**Jacobs Douwe Edberts, Ruscote Avenue,  
Banbury, Oxfordshire, OX16 2QU**

**22/01944/NMA**

**Proposal:** Omission of cladding following demolition; relocation of one car parking space; removal of speed bumps; and revision to pedestrian crossing to provide improved pedestrian access (proposed as non-material amendment to 21/04144/F)

TITLE
Proposed Computer Suite West Elevation

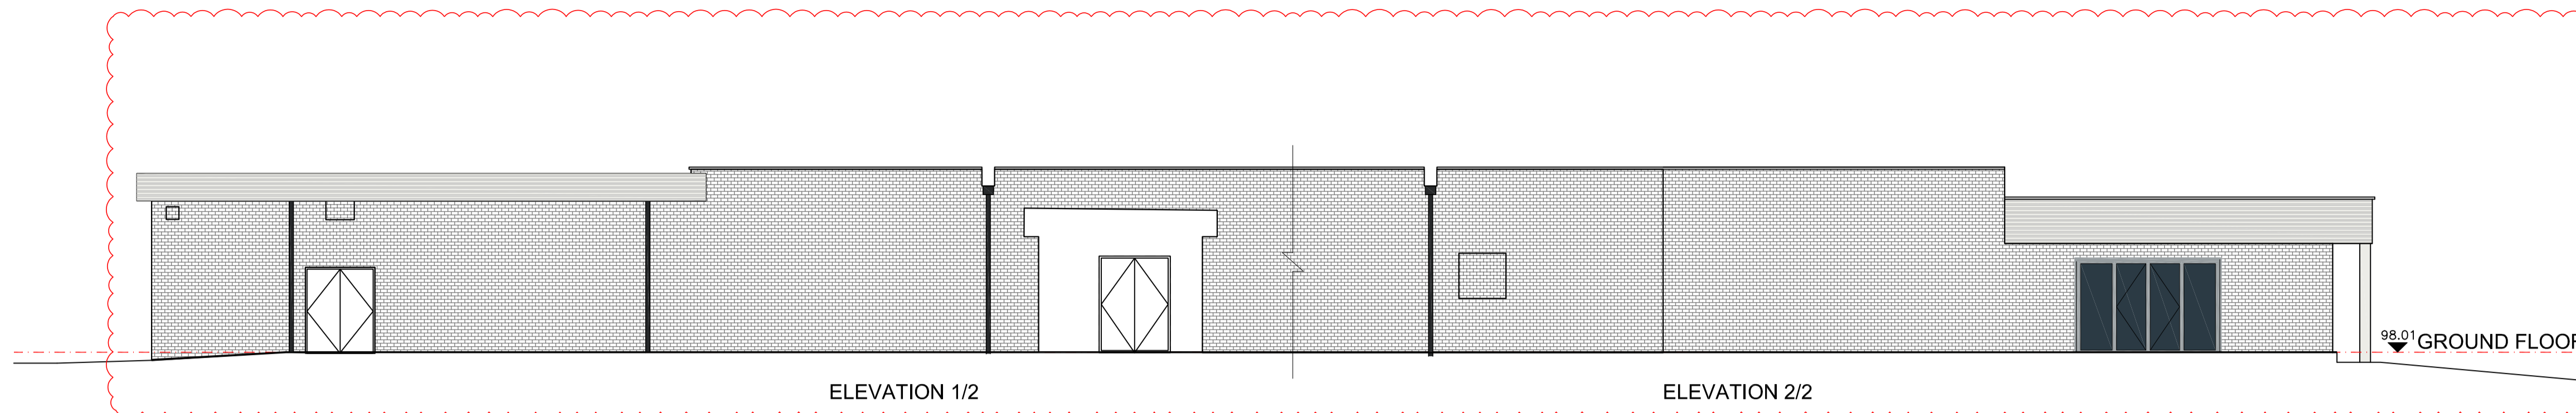
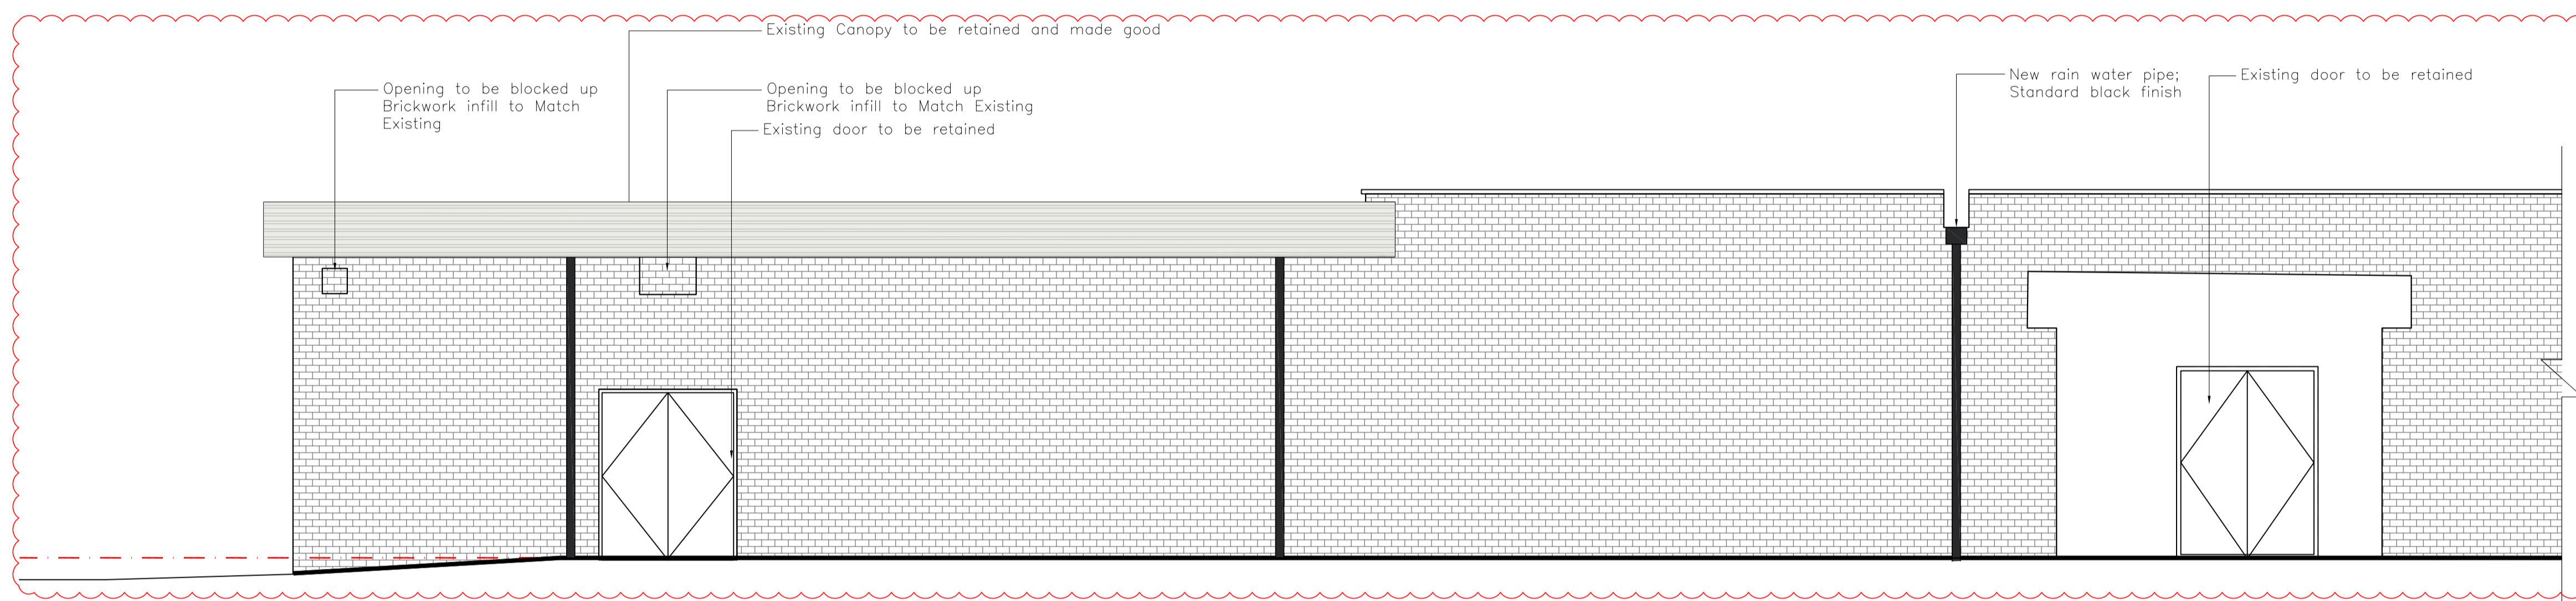
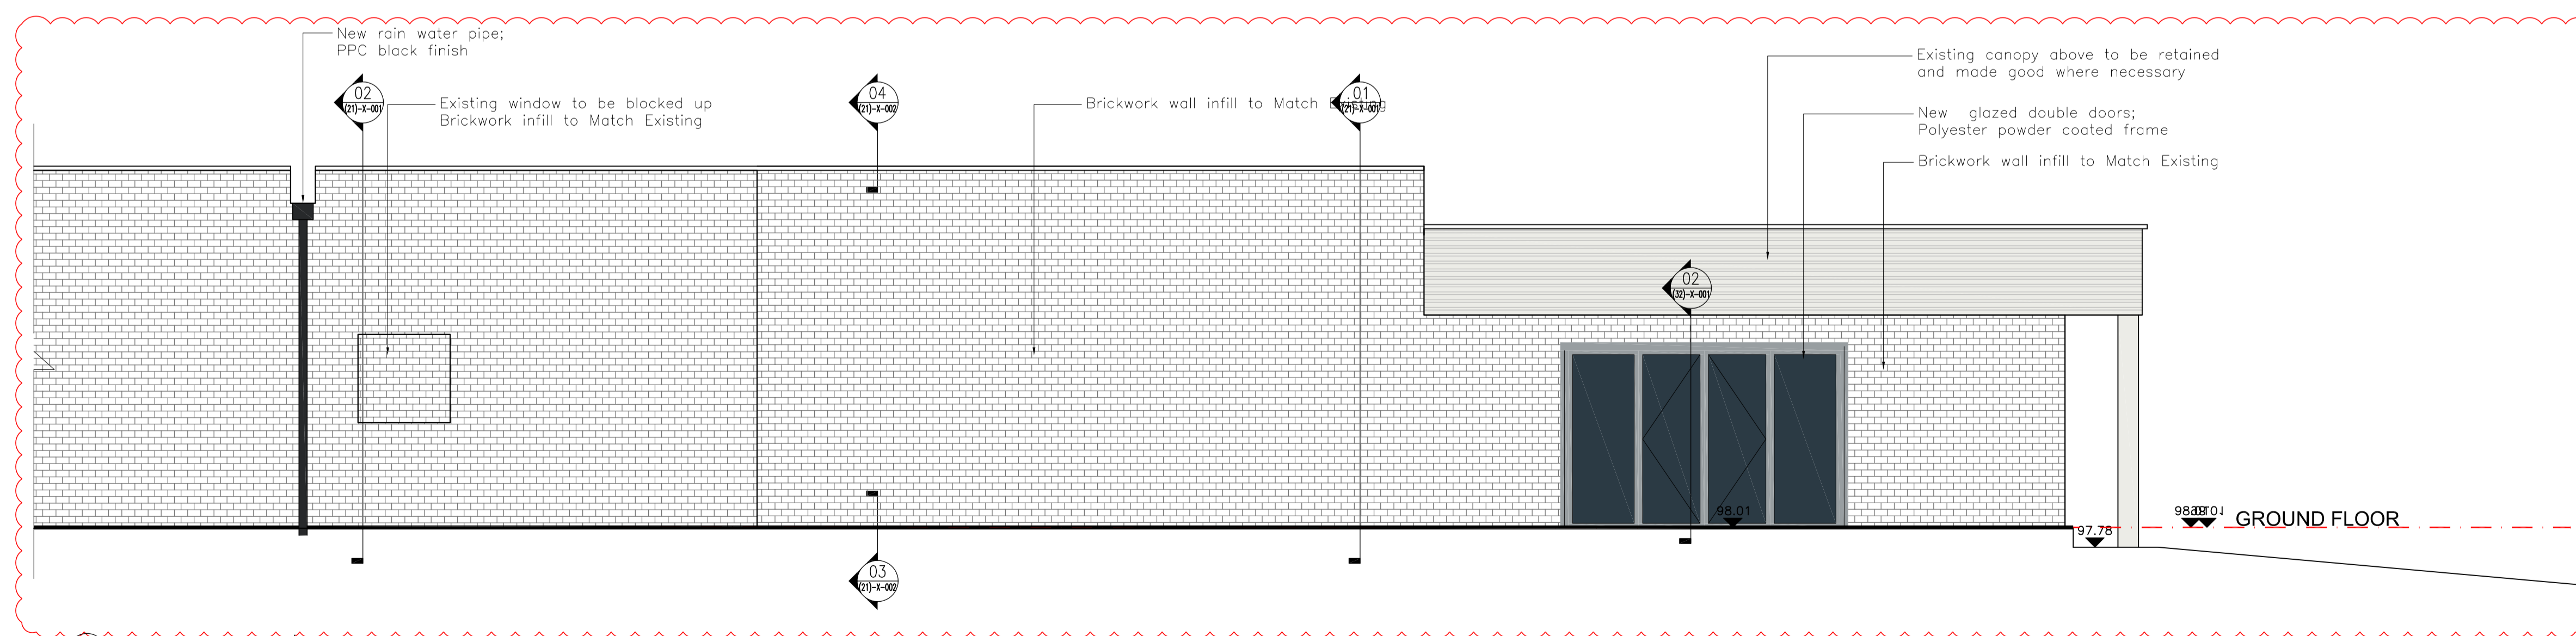
- 5.4. Whilst the omission of the cladding would result in a change to the proposed materials, it would be replaced with brick to match the existing building and would not introduce a different material that would affect the external appearance of the building.
